Planning Officer: Simon Davis

Planning Application Ref: AW/71/18/HH

Location: 36 Kingsway, Aldwick

Description of works: Demolition of existing ground floor extensions to front of property, construction of a single storey rear extension and reworking of existing external hard and soft landscaping. This application affects the character and appearance of the Craigweil House Conservation Area.

Drawing
Arboricultural Impact Assessment,
Arboricultural Method Statement

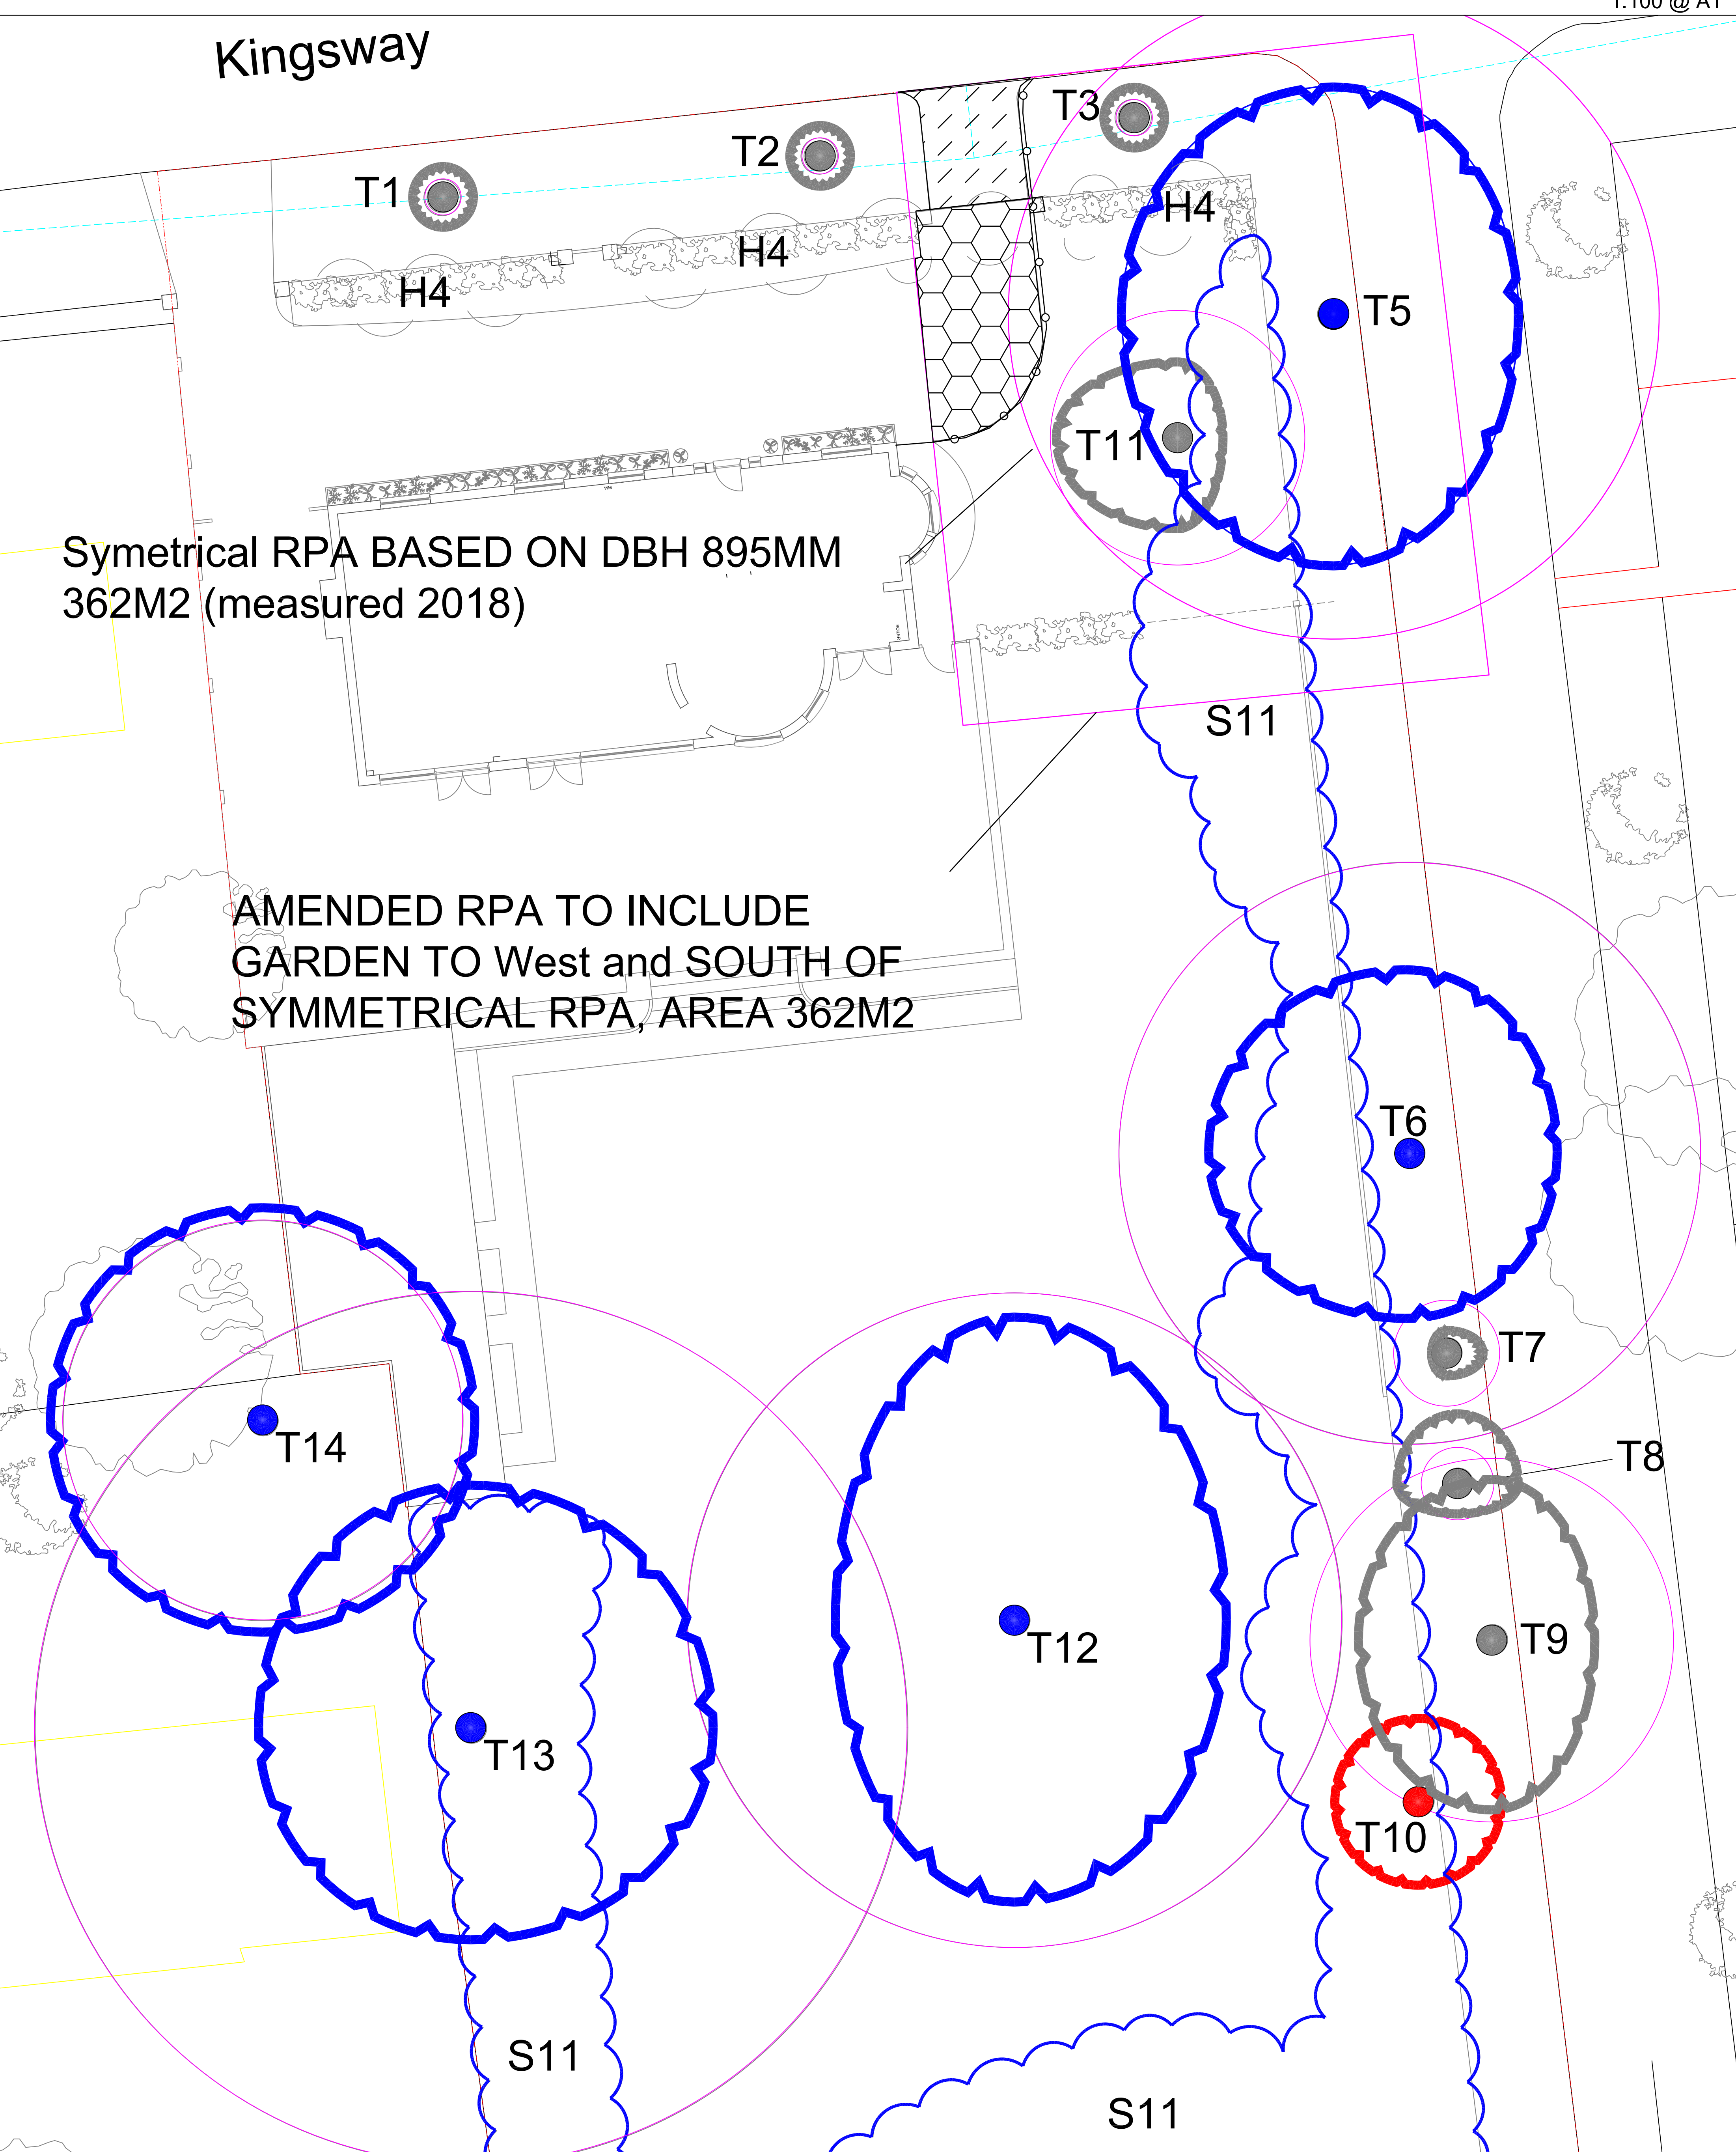
- I would need to see a revised and asymmetric RPA for T5 that adequately compensates for the impediment to root growth as described earlier, before I could consider lending this scheme my full approval. This will require the re-positioning of the second driveway access further west; an alternative ‘No-dig’ method of construction in the proposed position would demand ground level changes that are unlikely to be acceptable to the applicant. All parties have agreed that ground level changes necessary to accommodate the proposed ‘No-dig’ solution within the curtilage of the property are achievable and tolerable. As such the original proposed location of the new driveway access is acceptable. I accept the specification as detailed in **Cellweb Section – Tree Root Protection drawing no. GS-CW-BP-75** is adequate for its intended use.

- I have two minor outstanding concerns which ought to be easily overcome, but nonetheless should be reflected in a revised AIA/AMS:
 - I request confirmation that the area of ‘No-dig’ is undisturbed and adequately protected (it lies within the RPA) at the outset and immediately prior to installation of the cellweb construction layer. The ground protection measures necessary to achieve this should be determined by the project arboriculturist, with reference to the recommendations made in BS5837:2012, section 6.2.3.

- Paragraph 8.1 of the AIA report should be amended so that it does not support the stripping of soil within the ‘No-dig’ area and explicitly states such practice is confined only to the verge outside the curtilage of the property.

- As it stands, I must raise an **OBJECTION** to this application in its current form.
- RPA measurements (radial spread and area) must be added to the tree survey schedule to inform the process. The greater measurement of 895mm has now been recognised and informs the revised RPA (polygon). The agreed RPA broadly follows the indicative plan below but rejects the irregular element over carriageway in Kingsway and compensates with a comparable area of extension to the south – which I am able to support. The mutually agreeable RPA is detailed on the **AIA/AMS drawing no.602 – Rev B**.

Tree Survey, Arboricultural Impact Assessment, Arboricultural Method Statement Report, prepared by the Landscape Partnership, March 2018 (revised July 2018), including Tree Protection Plan dwg.no. **AIA/AMS drawing no.602 – Rev B**. and **Cellweb Section – Tree Root Protection dwg no. GS-CW-BP-75**.
